Application no: **3/2021/1017**

Address: **Overdale Dilworth Lane Longridge PR3 3ST**

Proposal: **Discharge of conditions 6 (Construction Method Statement) and 7 (scheme for retaining structure) of application 3/2020/0885 (variation of 3/2018/0819).**

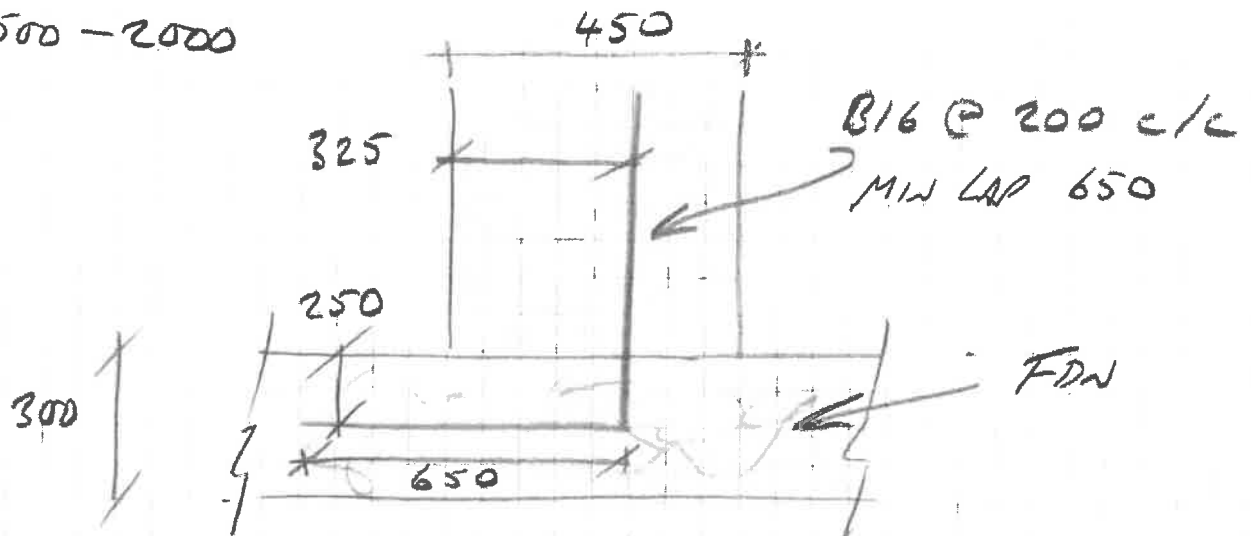
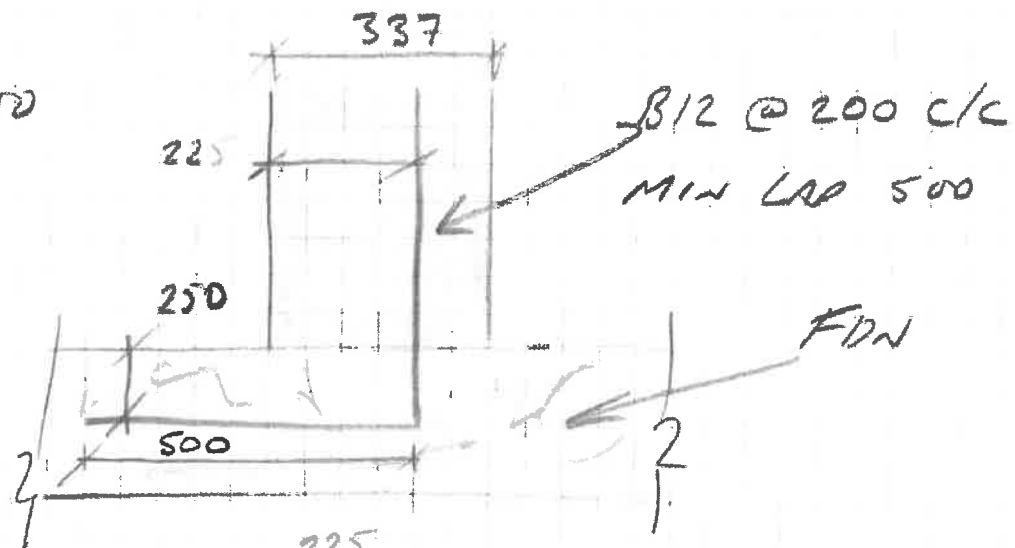
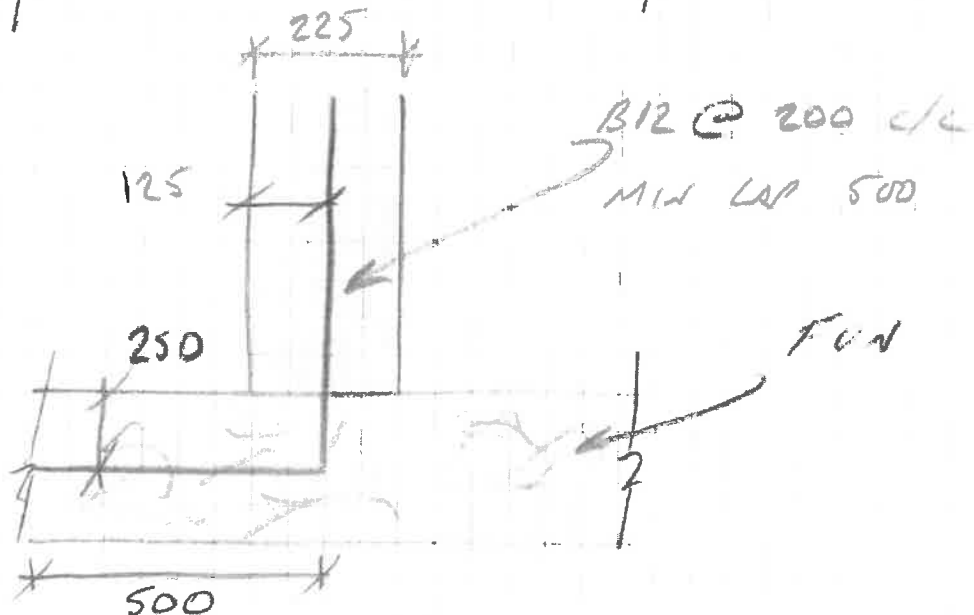
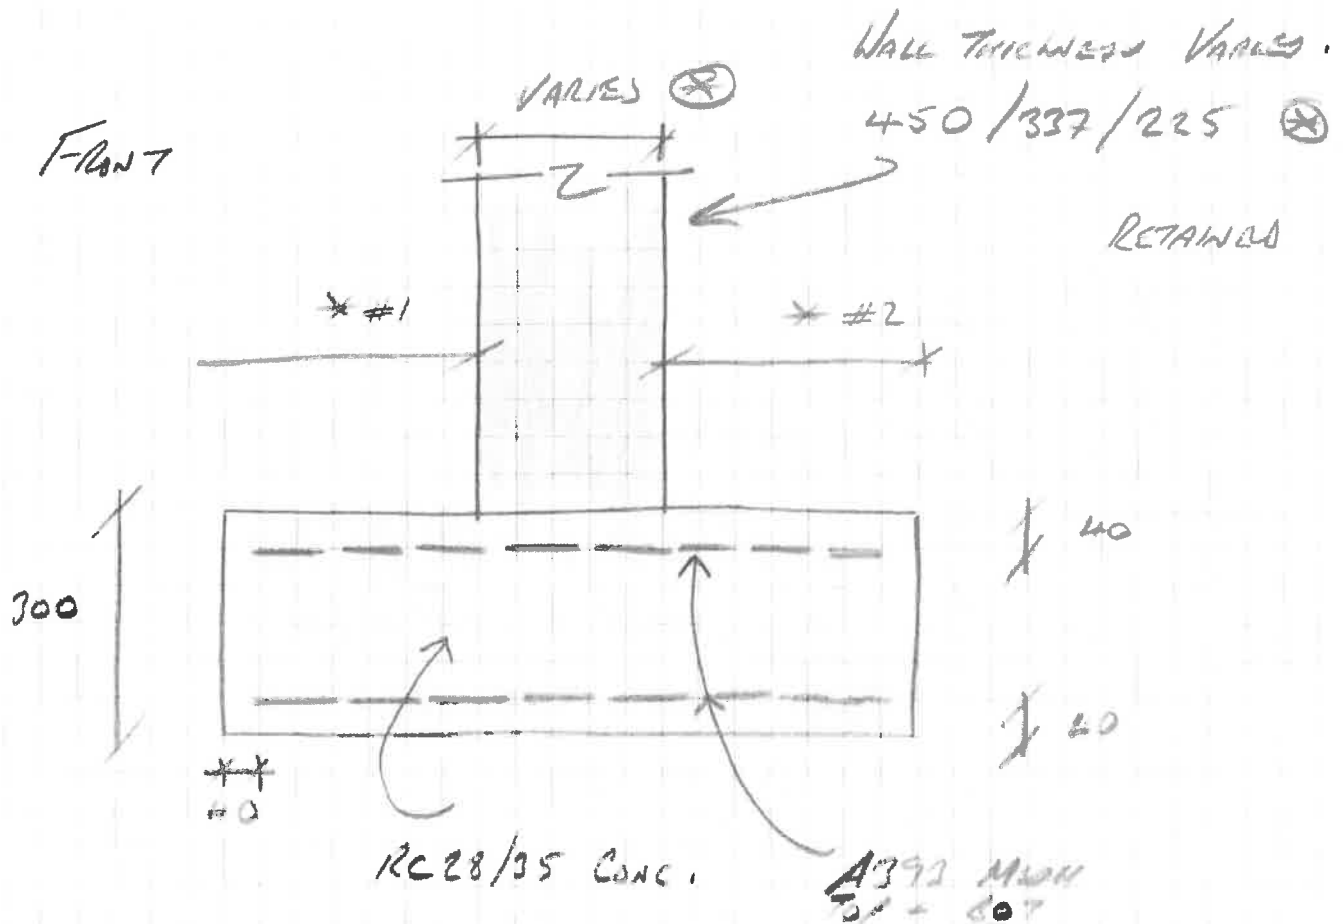
The LHA have reviewed the supporting documents and are requesting a clearer drawing is provided of the retaining wall showing the location of each side section, when applicable.

The LHA remind the Applicant that any retaining feature higher than 1.5m to the public footway along Calfcote Lane, means that a Structural Agreement is required between the LHA and the Applicant.
